Dogger Bank South Offshore Wind Farm

Appendix C6 to the Natural England Deadline 6 Submission
Natural England's comments and updated advice on Benthic and Intertidal Ecology

Planning Inspectorate Reference EN010125

13th June 2025

**Figure 5-1 Changes to bed shear stress due to tidal wake effects at DBS (modelling presented in Appendix 8.3 Marine Physical Processes Modelling Technical Report [AS-135])**

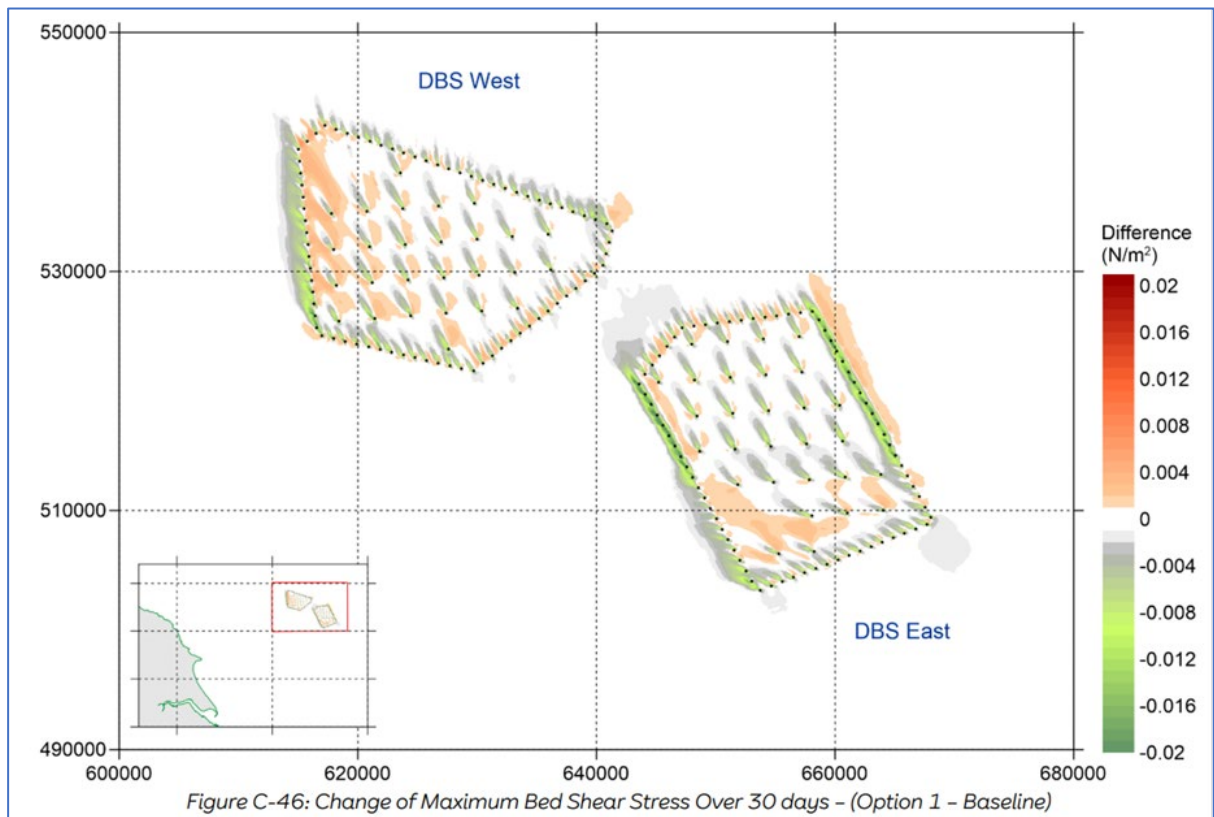
NE Ref	Section	Key Concern and/or Update	Natural England's Advice to Resolve Issue
7	Para 60	Natural England does not agree that commercial fishing activities within the array areas will remove the likelihood of localised changes to trophic levels interactions/predation on the benthic communities in the vicinity of hard structures. Such assumptions would require the notion to be made that commercial fishing leaves the area altogether devoid of pelagic species (noting that the area is already closed to bottom towed gear).	Please see Comment 4 above.
8	Para 69	<p>Natural England considers that the Applicant appears to be confusing pathways of effect from tidal wake effects/changes to bed shear stress on benthic community receptors, with those from ecological halo effects. We advise that benthic community changes and pathways of effect brought about by changes in shear stress and those induced by ecological halo pressures are different.</p> <p>Whilst we agree the ecological halo is unlikely to be uniform and will present an asymmetrical form to some degree, we do not consider it's an appropriate worst-case scenario to assume that effects from ecological halo's would be restricted to 25% of the total seabed surrounding hard structures. Such an assumption would also incorrectly assume that changes to trophic level interactions were also asymmetric in extent.</p>	Natural England advises that in the absence of further evidence, the extent of the ecological halo should be considered separately from the extent of changes in bed shear stress.
